# Rezoning Transportation Analysis

Petition Number: 2019-173

Date	Description
01-17-2020	First Review
05-20-2020	Second Review (WB)
09-22-2020	Third Review

GARRISON ROAD INDUSTRIAL
 REZONING PETITION NUMBER 2019-173
 CHARLOTTE, NORTH CAROLINA
 MCCRANEY PROPERTY COMPANY
TRANSPORTATION IMPROVEMENT PLAN

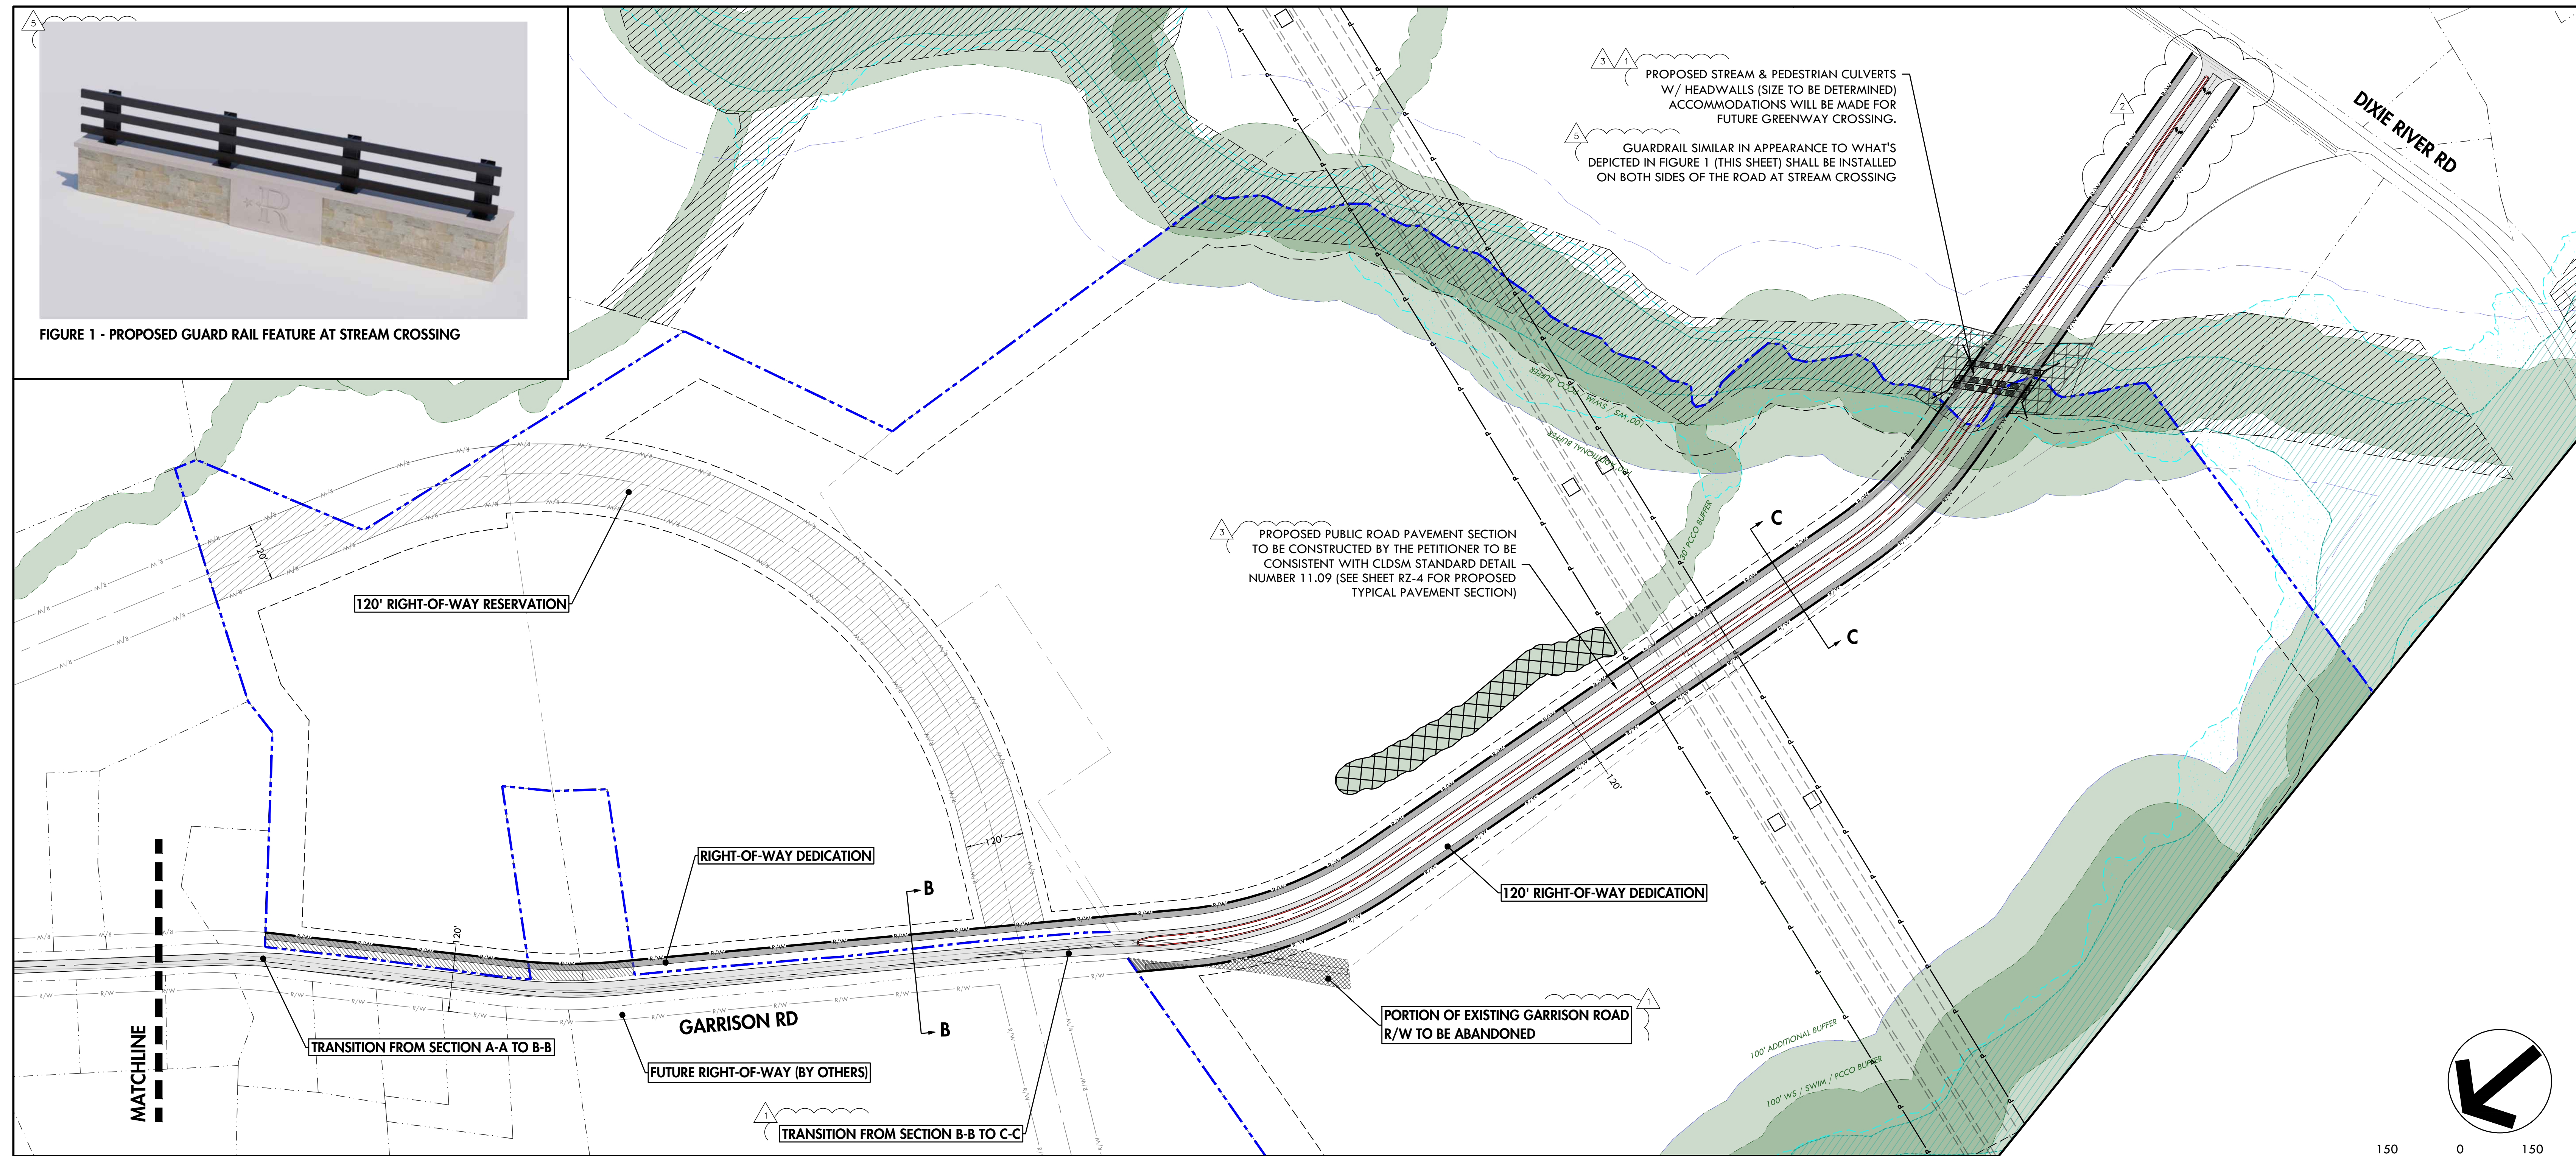
12. **New Comment based on revised site plan 08-24-2020:** Revise the site plan and conditional note(s) to commit to constructing left-turn lanes, with the appropriate storage and bay taper, within the center median at the proposed access points for Development Areas B, C, and D within Phase 1. CDOT encourages the petitioner to align opposing driveways and/or condense the number of proposed access points on Realigned Garrison Road, to minimize the number of left-turn lane bays required.

13. **New Comment based on revised site plan 08-24-2020:** Revise the site plan and conditional note(s) to update the proposed road centerline options of the West Boulevard Improvements and Alternative Garrison Road Improvements to Horton Road, per the latest West Boulevard Improvement design that is shown below.

14. **New Comment based on revised site plan 08-24-2020:** Within the scope of the proposed Phase 2 improvements, revise the road centerline dimensions to comply with AASTHO Green Book minimum centerline radius standards for a major arterial.
15. **New Comment based on revised site plan 08-24-2020:** Revise the site plan and conditional note (Section 3.a.(3).b.ii.) to clarify whether the public right-of-way that is required is for the temporary condition (60-ft) or future condition (120-ft).

SECTION A - A
PROPOSED ROAD IMPROVEMENTS
(FUTURE BY OTHERS)

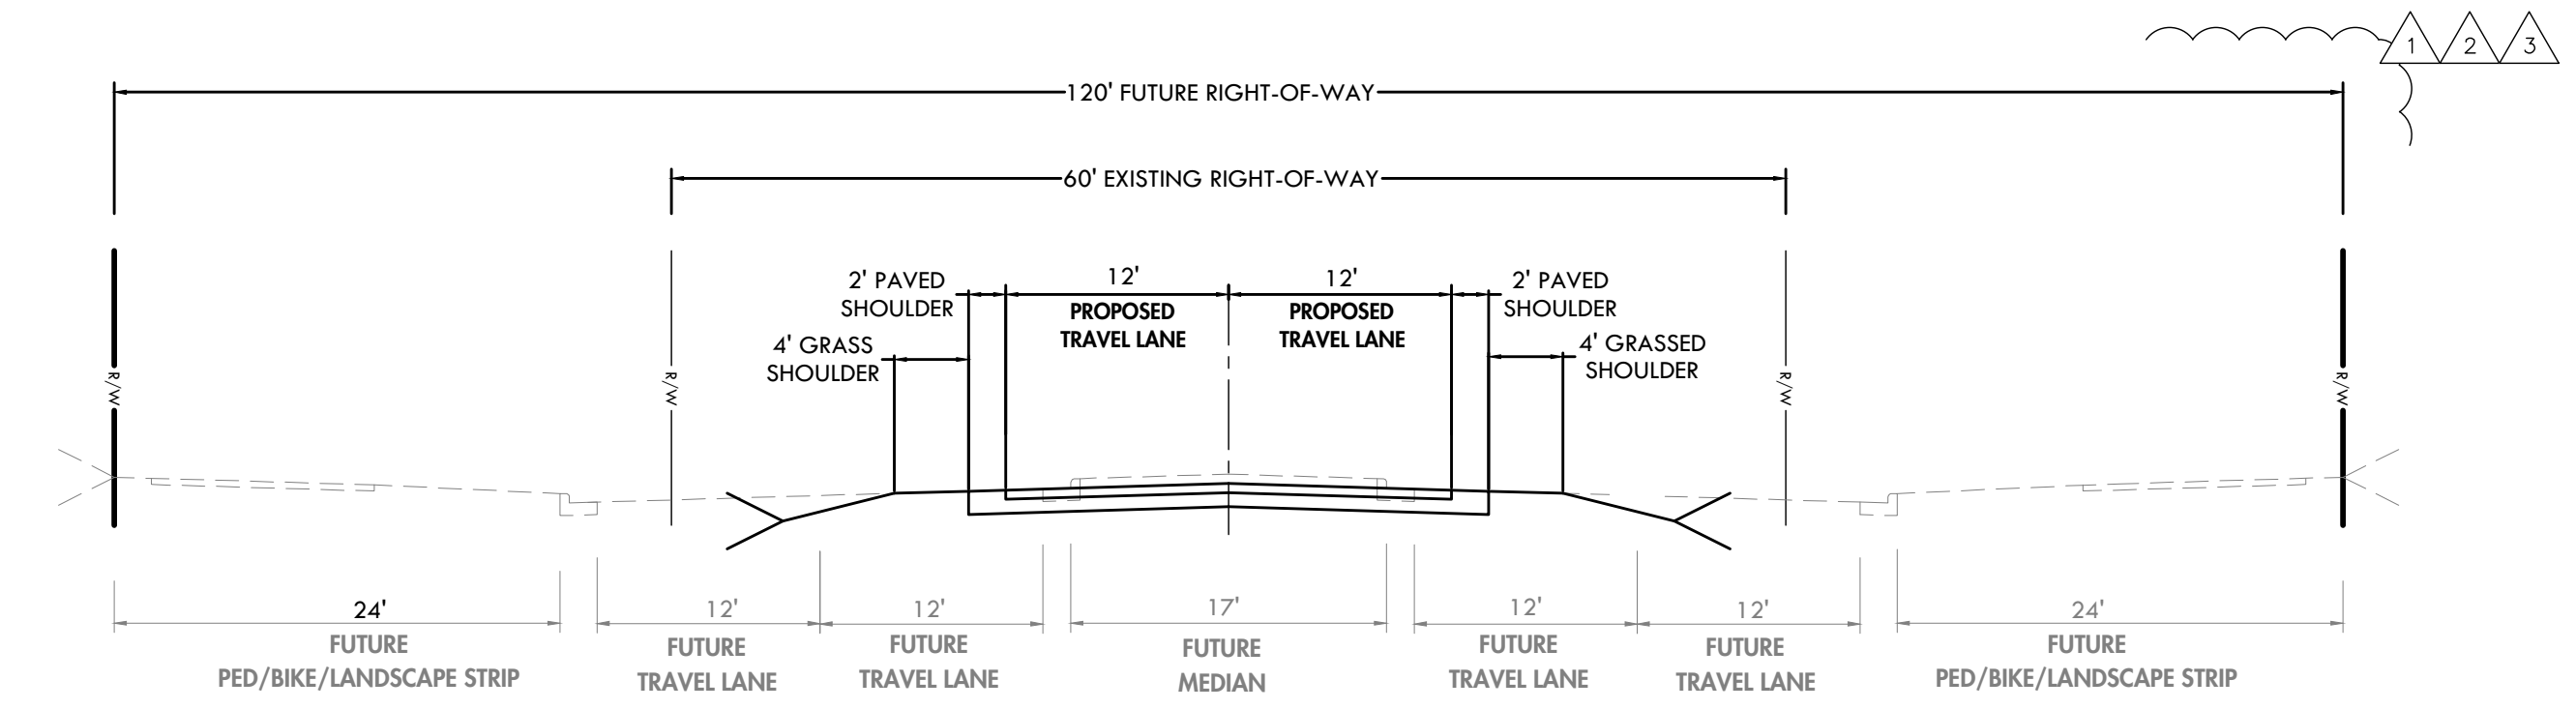
6. ~~New Comment based on revised site plan 05-11-2020:~~ The petitioner should revise the site plan and conditional notes to commit to construct 2-12' lanes with 2' paved shoulders and 4' grass shoulders. for Section A-A. **Outstanding:** Add a note stating the final details will be determined during the permit review process to include input from other departments including but not limited to CDOT, General Services, Charlotte Fire Department, and NCDOT. Also include that any applicable ordinance requirements in addition to what is shown on proposed cross-sections may be required.

SECTION B - B
PROPOSED ROAD IMPROVEMENTS
(FUTURE BY OTHERS)

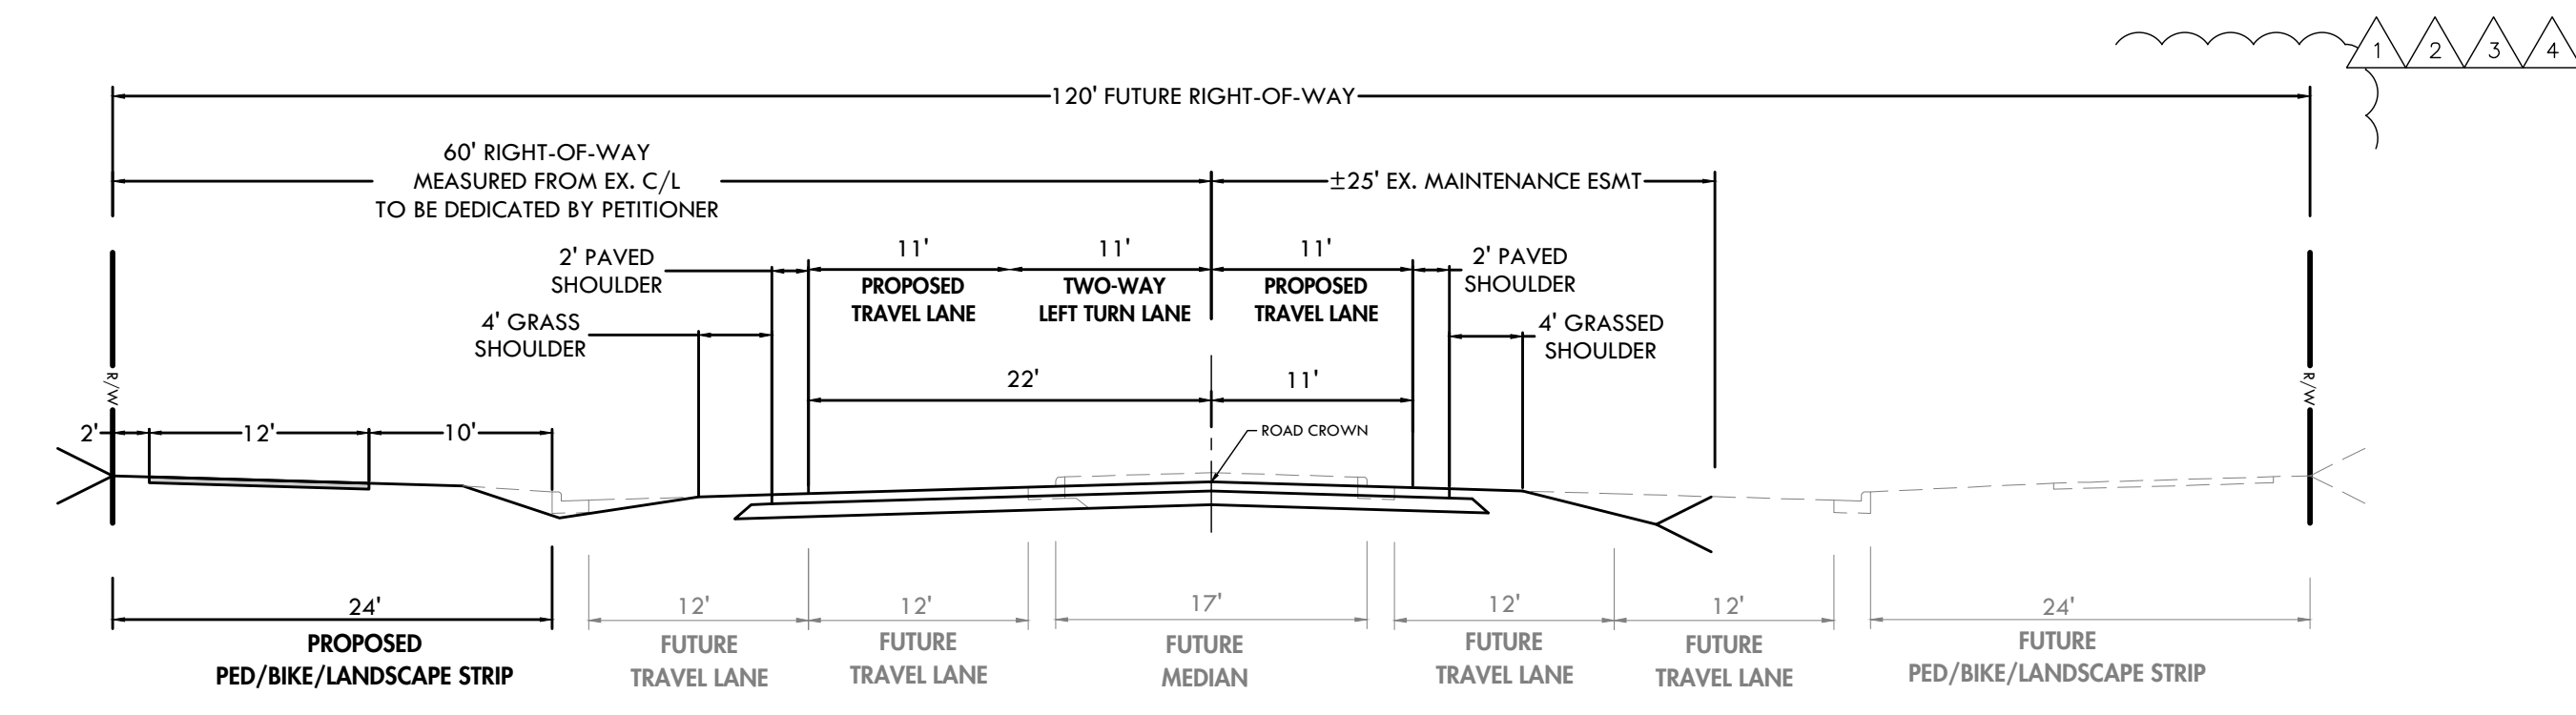
- a. **New Comment based on revised site plan 08-24-2020:** Revise Section B-B to the redlines below, reflecting the latest coordination between CDOT and NCDOT. A three-lane section with a center two-way left-turn lane will provide median space for left turns into the proposed access points for Development Area A. CDOT encourages the petitioner to consider condensing the number of access points for Development Area A on the along the Realigned Garrison Road.

SECTION C - C
PROPOSED ROAD IMPROVEMENTS
(FUTURE BY OTHERS)

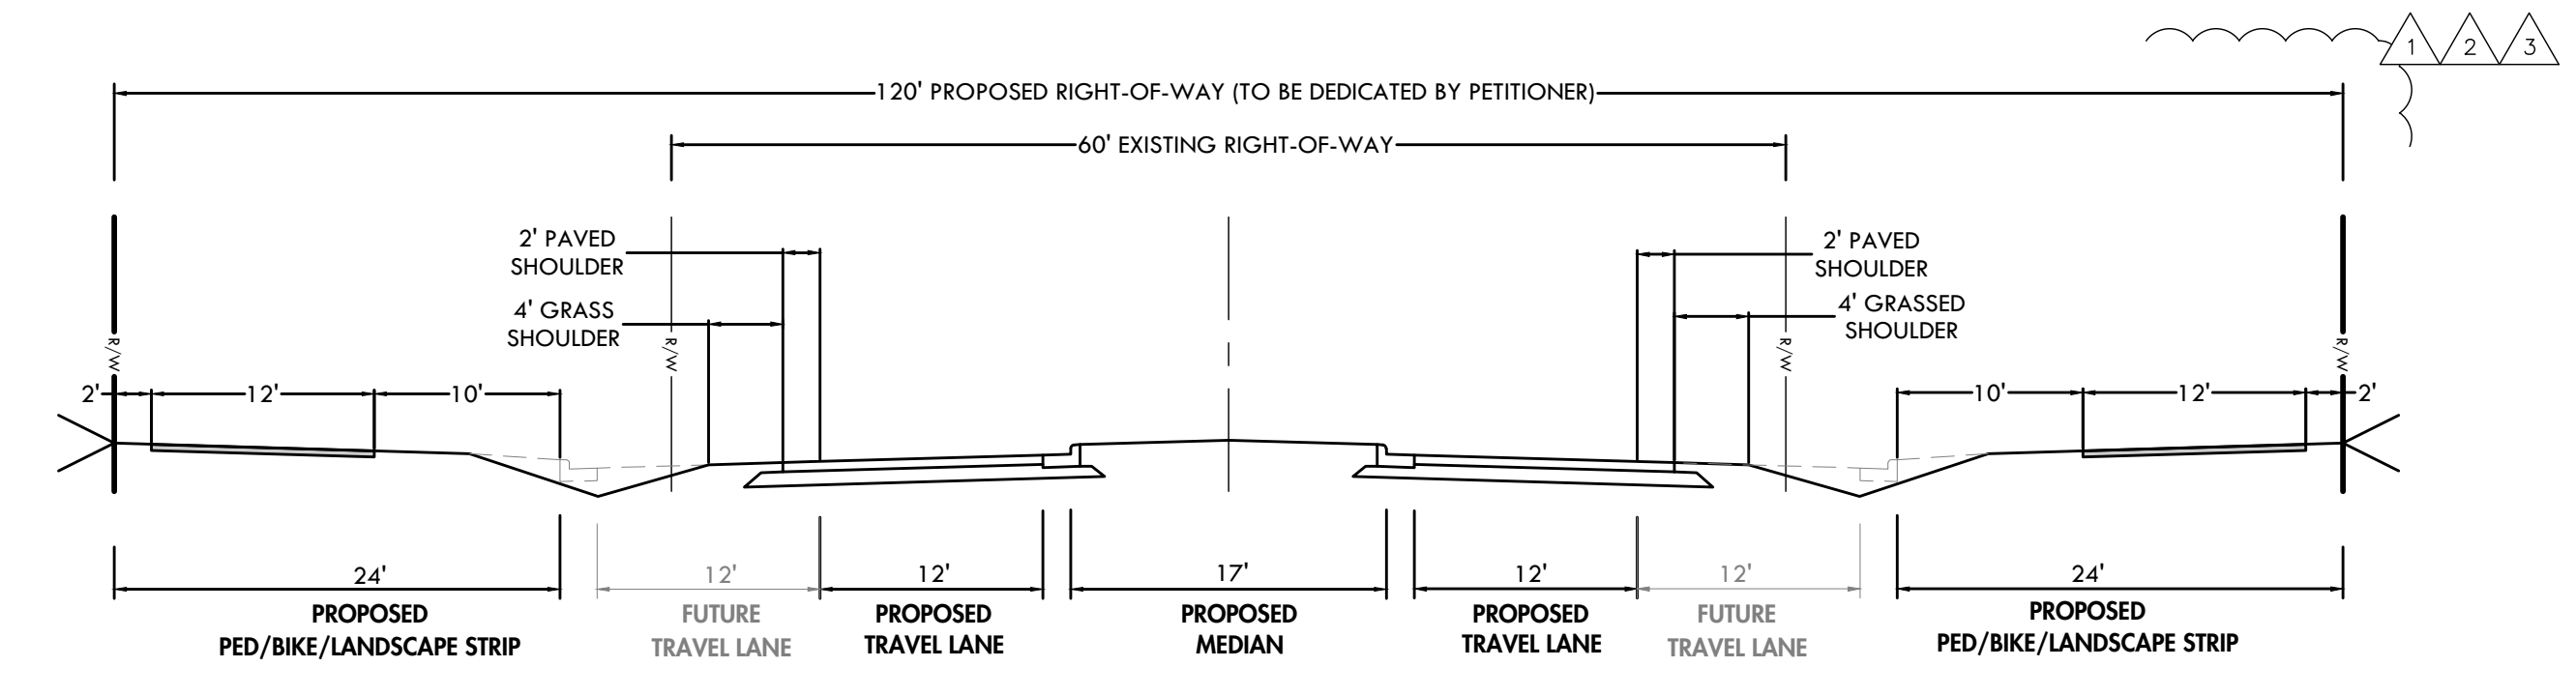
8. ~~New Comment based on revised site plan 05-11-2020:~~ Cross-section C-C depict the general intent of a 3-lane section (2 travel lanes and center turn lane and/or planted median) and a shared-use path for an interim version of future Garrison Road. The petitioner should revise the site plan and conditional notes to commit to construct 2' paved shoulders and 4' grass shoulders.

**Outstanding:** Add a note stating the final details will be determined during the permit review process to include input from other departments including but not limited to CDOT, General Services, Charlotte Fire Department, and NCDOT. Also include that any applicable ordinance requirements in addition to what is shown on proposed cross-sections may be required.
